Our Ref: BE/74/19/PL

**Town & Country Planning Act 1990 (as amended)
Town and Country Planning (Development Management Procedure) (England) Order 2015
Application for Planning Permission**

Development Construction of entrance door & ramp on east elevation
Location 218 Chichester Road North Bersted

EAST ELEVATION TO 218
CHICHESTER RD. N-BERSTED
SHOWING NEW DOOR
Scale 1:100

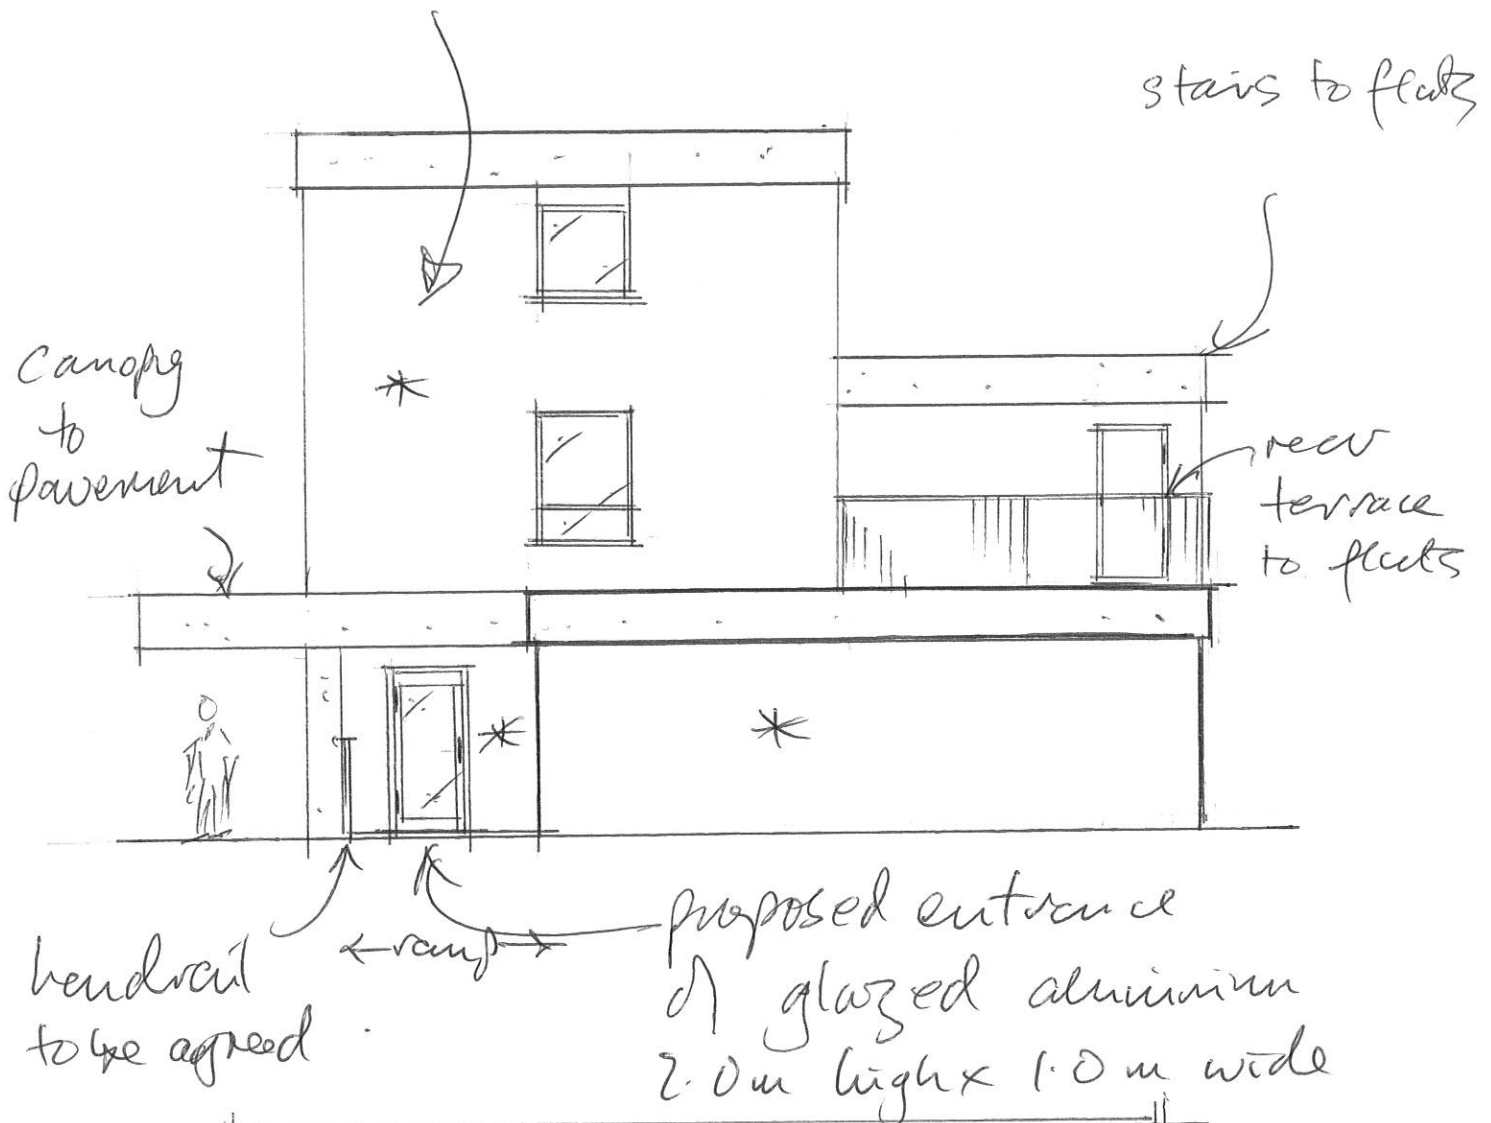
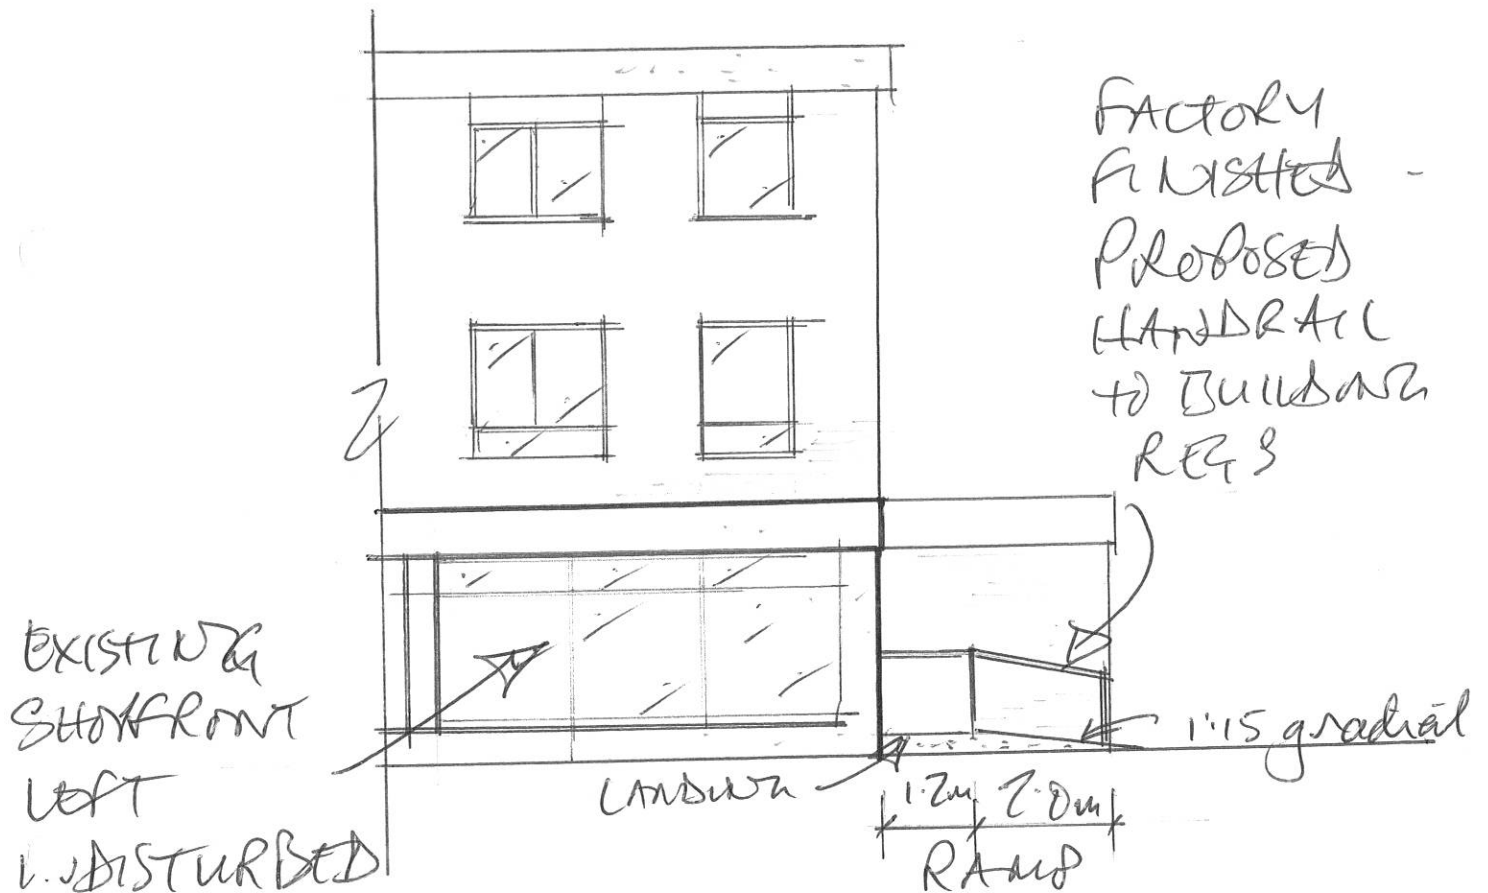
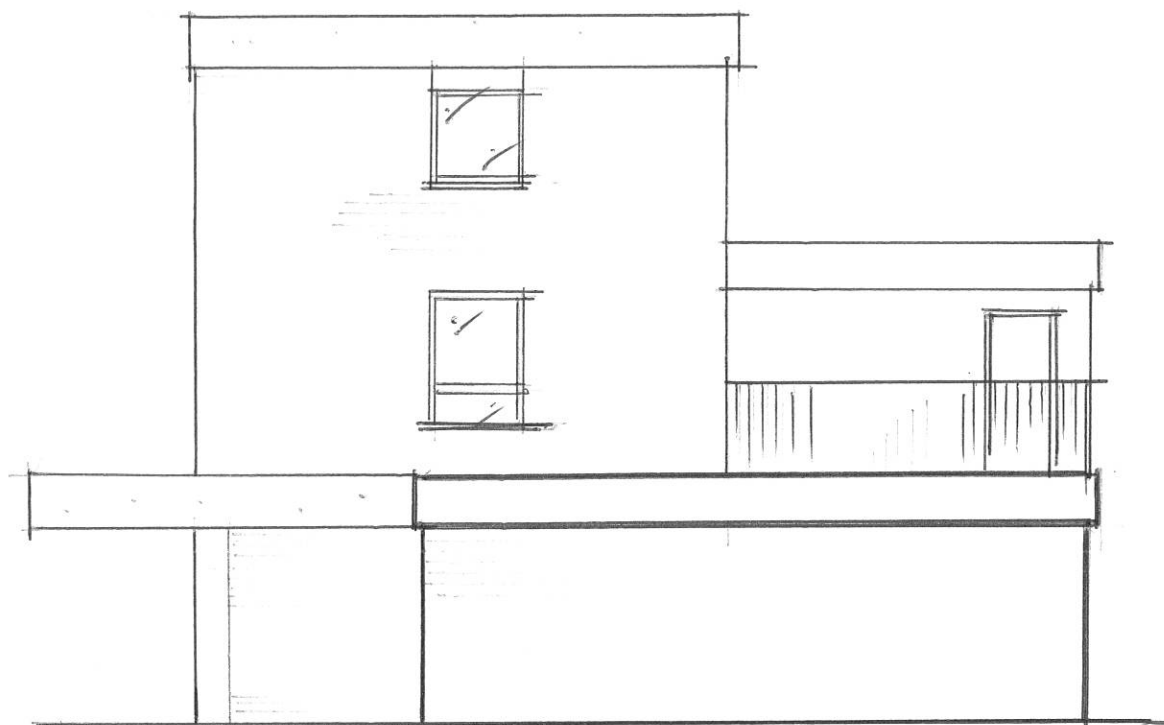
Elevations

Please submit 1 electronic or 3 paper copies of amended elevations to scale clearly showing the existing and proposed elevations and the ramp details/sections

EXISTING &
PROPOSED
PLANS @ 1:100
218-222
CHICHESTER RD
N. BERSTED
2019.

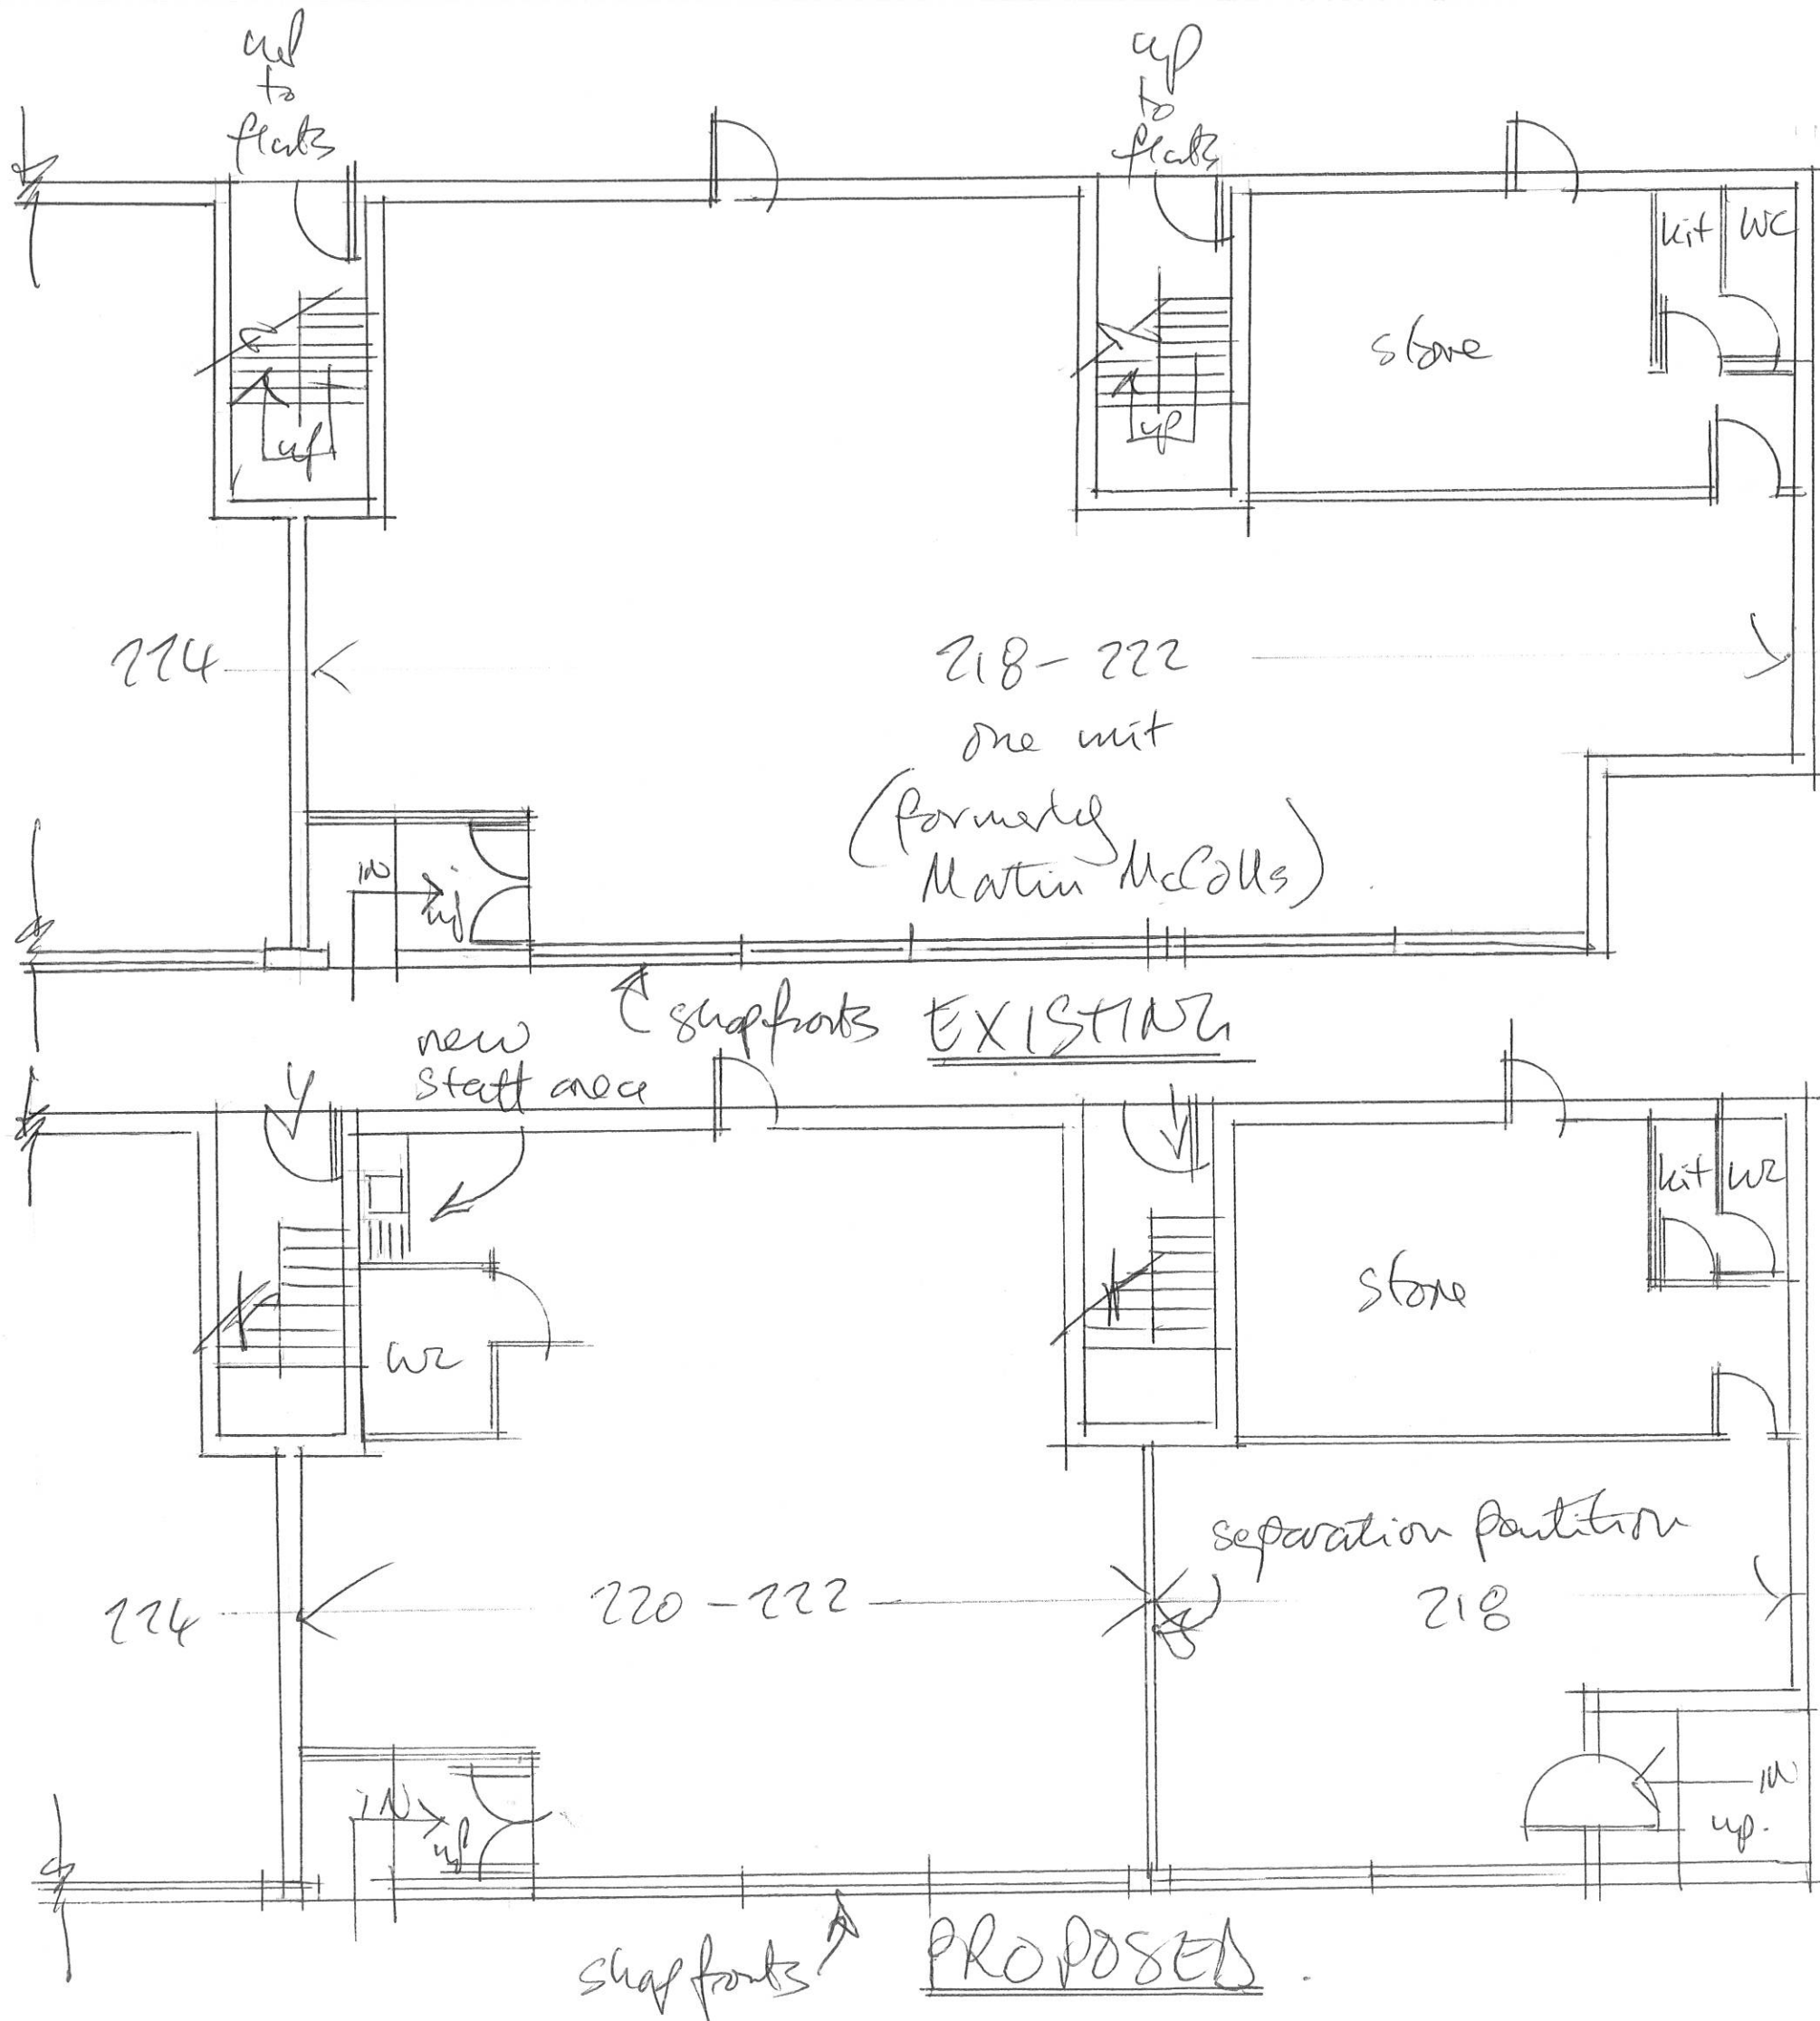
Floor Plans

Please submit 1 electronic or 3 paper copies of clearly labelled existing and proposed floor plans at a scale of 1:50 or 1:100. Further details can be found in the National Validation Requirements.
